WELWYN HATFIELD COUNCIL – DEVELOPMENT CONTROL
DELEGATED REPORT

APPLICATION No:	S6/2007/511/FP
------------------------	-----------------------

DESCRIPTION OF PROPOSAL:

Drawing Title:
 Proposed 2 Storey Extension
 Proposed Elevations

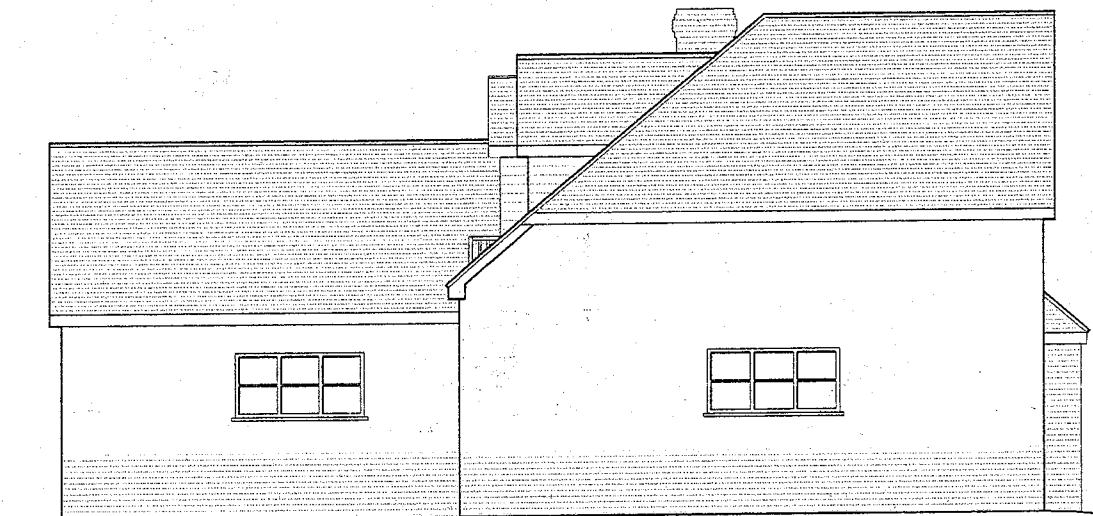
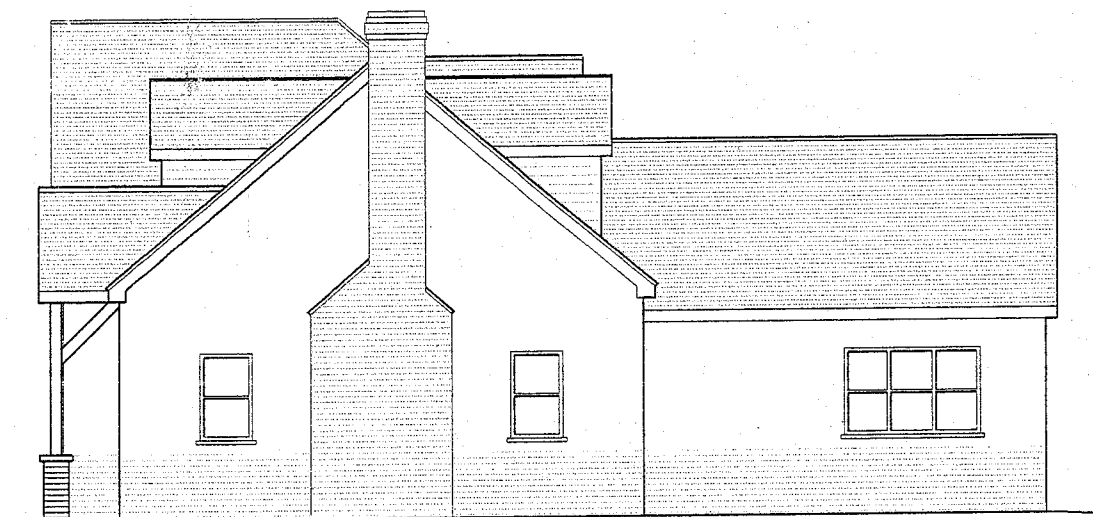
In addition, this planning application also seeks permission for a projecting ground floor bay which is approximately 2.3 wide and 0.9m deep and front porch with a pitched roof, larger dormers than those currently approved and a new chimney. Changes are also proposed to the arrangement of the window fenestration to the rear and to one side elevation.

Turning to the overall visual impact of the proposal on the openness of the Green Belt, this is particularly important, as floorspace assessments in isolation may not suffice, as irrespective of the floorspace increase Policy RA3 also looks at the overall resultant size and its visual impact on the countryside. The approved changes (application S6/2006/1582/FP) are considered towards the limit of what would still comply with RA3, and the addition of a further pitched roof porch and ground floor projecting bay, porch and chimney would be particularly noticeable, and more so than just the slightly larger dormers and chimney proposed in application S6/2007/1418/FP. These additional changes would further impact on the visual openness of the Green Belt to an extent that, when taken into account those already permitted, the cumulative increase would be disproportional to the original dwelling.

The overall design of the dwelling, therefore, would have an adverse visual impact on the countryside and would represent an inappropriate form extension and so fails to comply with Policy RA3 of the Welwyn Hatfield Plan 2005 and the requirements of PPG2.

The porch, larger dormers, chimney and projecting bay are relevant as the other changes to the existing building were covered in the previous application.

The design of these additions would not be out if keeping with the resultant dwelling. The changes to the windows and door arrangement is also considered to be acceptable.

1. The proposal which is for additional extensions to those already approved by application S6/2006/1582/FP would, when considered cumulatively, result in a disproportionate increase in the size of the original dwelling due to its resultant appearance and from the increase in bulk and mass. This would diminish the openness of the Green Belt to the detriment of the rural character of the area contrary to the requirements of Policies RA1 & RA3 of the Welwyn Hatfield District Plan 2005 and Planning Policy Guidance Note 2 (Green Belts). There are no very special circumstances which have been advanced to justify a departure from the Green Belt Policies of restraint.

Drawing Title:
Proposed 2 Storey Extension
Proposed Floor Plans

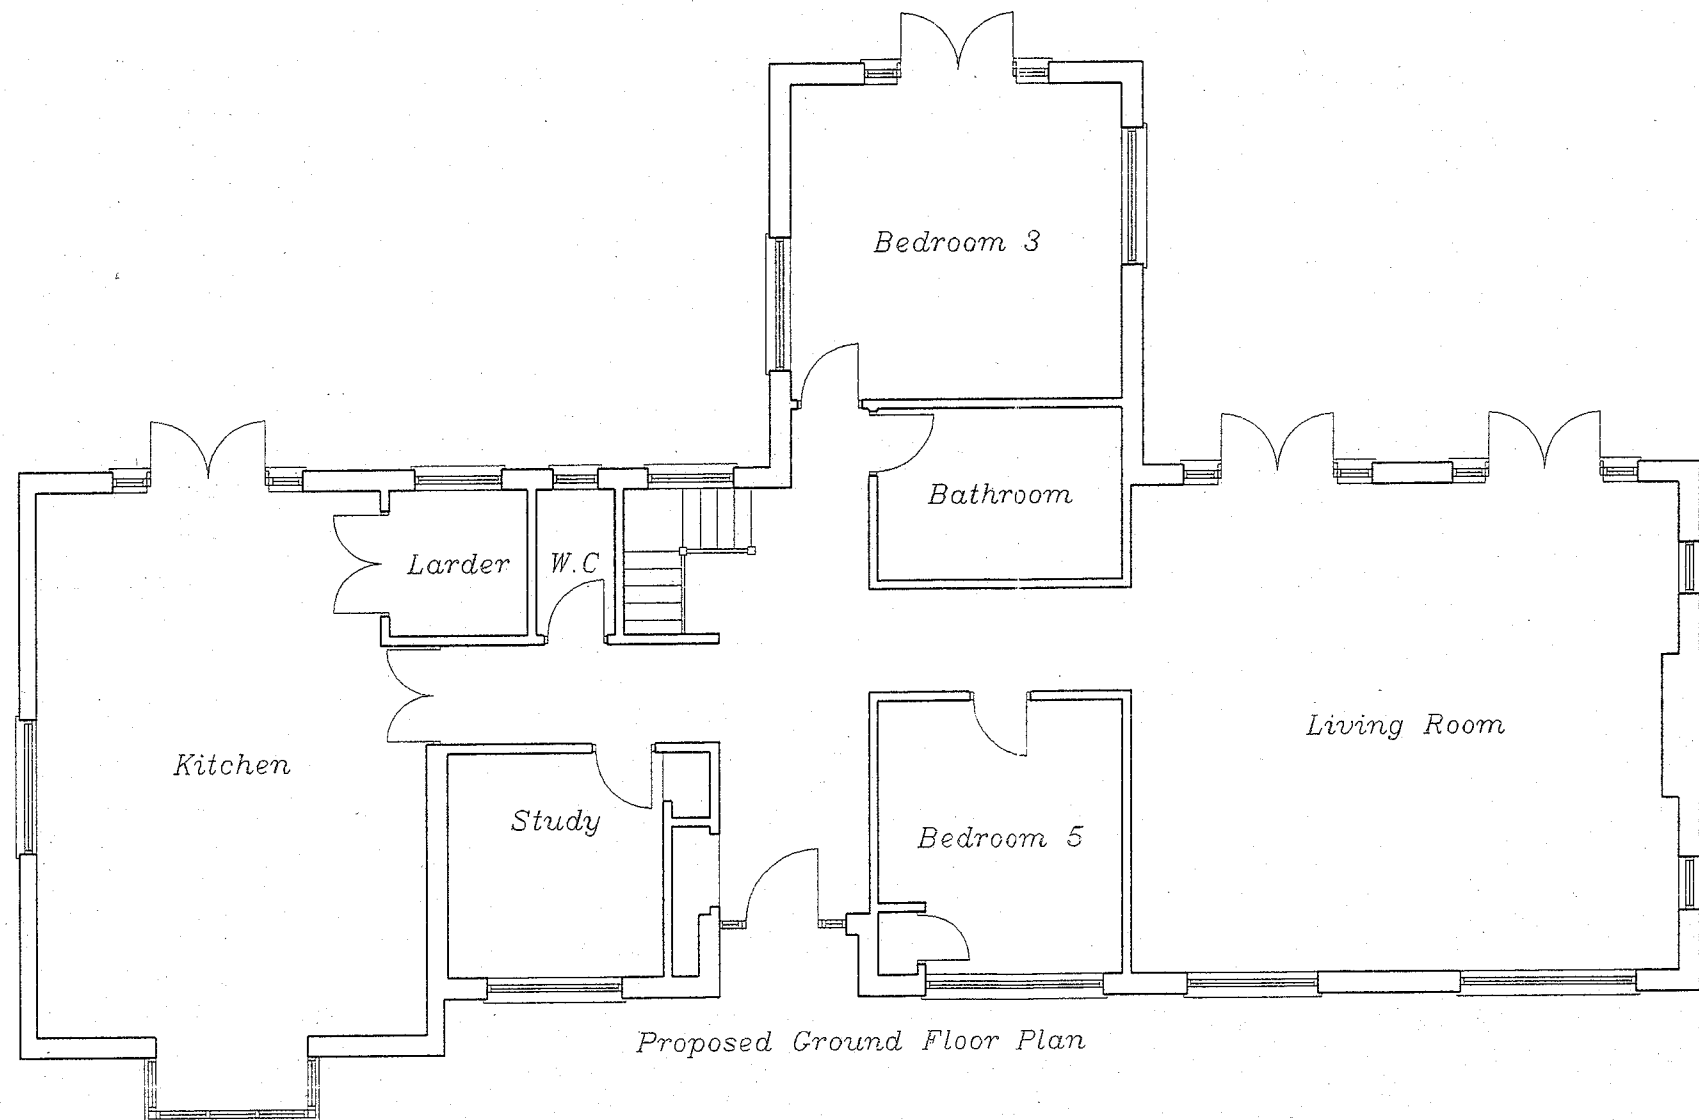
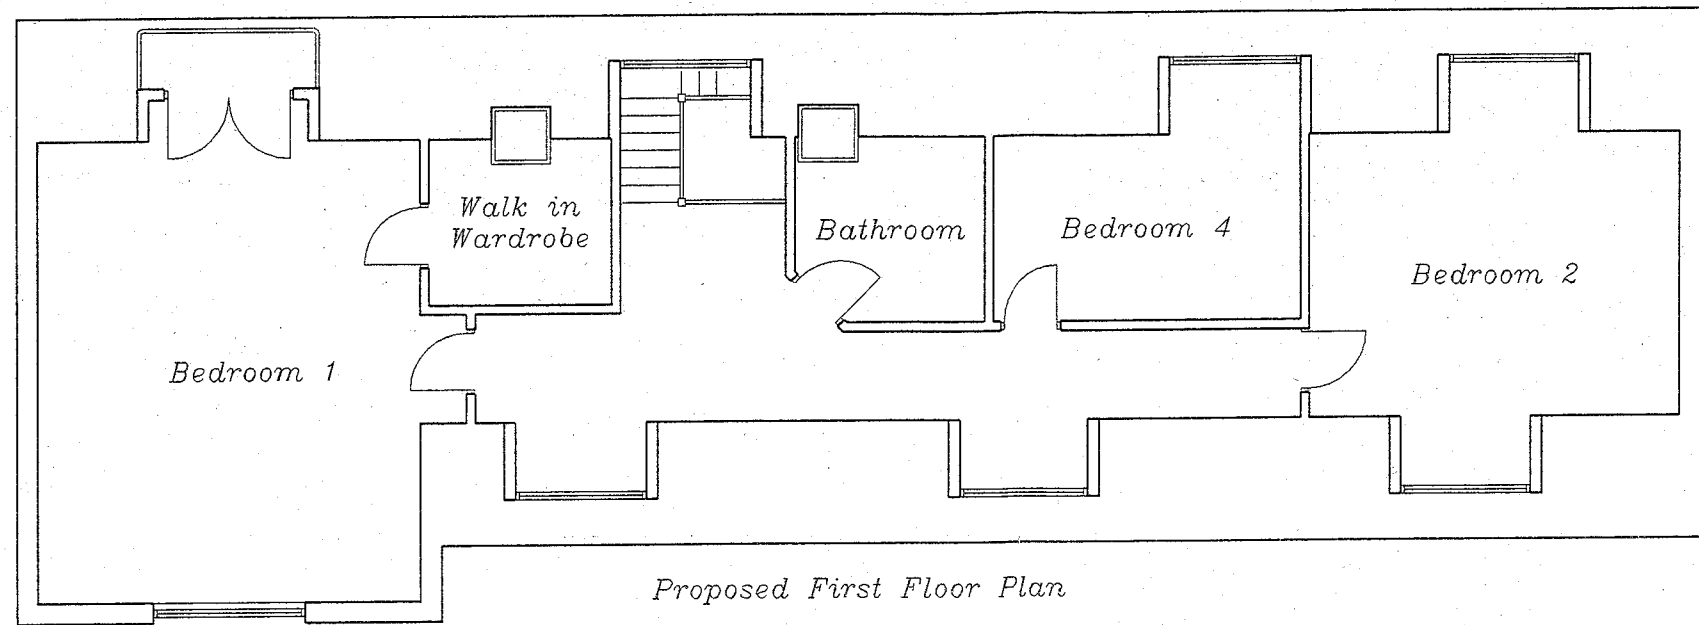
The previous proposal equated to an increase of 36% over and above the original dwelling which is not considered excessive or disproportionate in floorspace terms, and the current proposal would increase this by around another 3% which would be a small percentage. This additional floorspace would keep the percentage would not appear disproportionate when compared to the floorspace of the original dwelling. The changes to the window and door fenestration would also not result in any floorspace increase.

The existing access to Bell Lane is to remain unchanged, and although the existing garage is to be converted into habitable accommodation, there are at least 3 parking spaces to the front of the dwelling which is sufficient for the proposed 4 bedrooms. The proposal therefore complies with Policy M14 of the Welwyn Hatfield Plan 2005 and the accompanying Supplementary Design Guidance – Parking Standards.
